Re: Amendments to application: 61 Haig Road - **76194/APP/2021/1423**

P-06 PROPOSED FIRST FLOOR PLAN
B

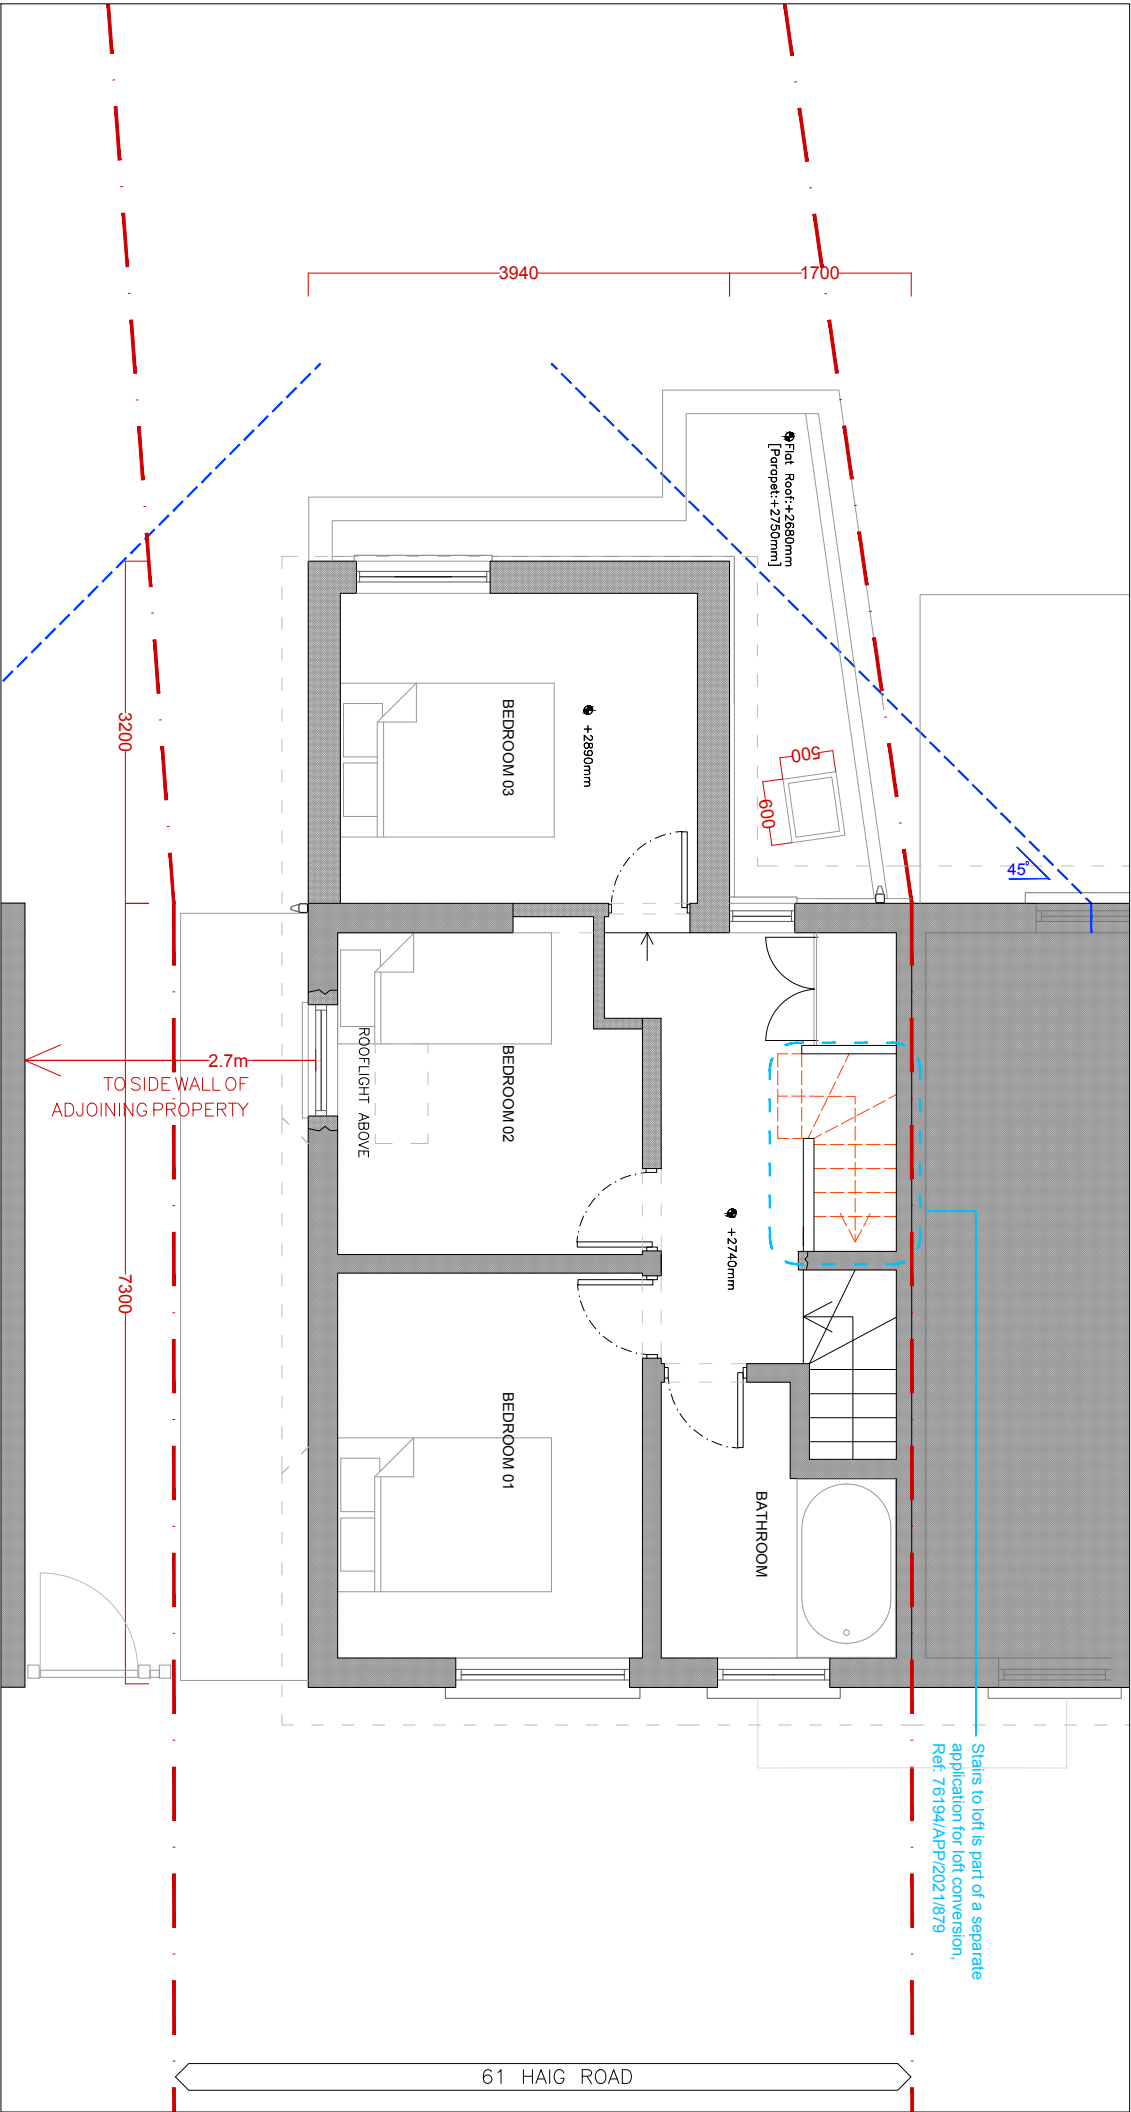
The issue is that as the first floor element covers the whole width of the rear elevation of the house, it can not be considered to be a subordinate addition. The crown roof study room needs to be omitted and the width of the rear first floor extension reduced.

The crown roof study area has been removed.

The set-back of the proposed first floor block is now 1.7m from the property boundary.

An altered route from first floor landing to the proposed new bedroom addition is shown in the first floor plan.

Otherwise, the bedroom portion of the proposed first floor rear extension remains unaltered, in its exterior dimensions.
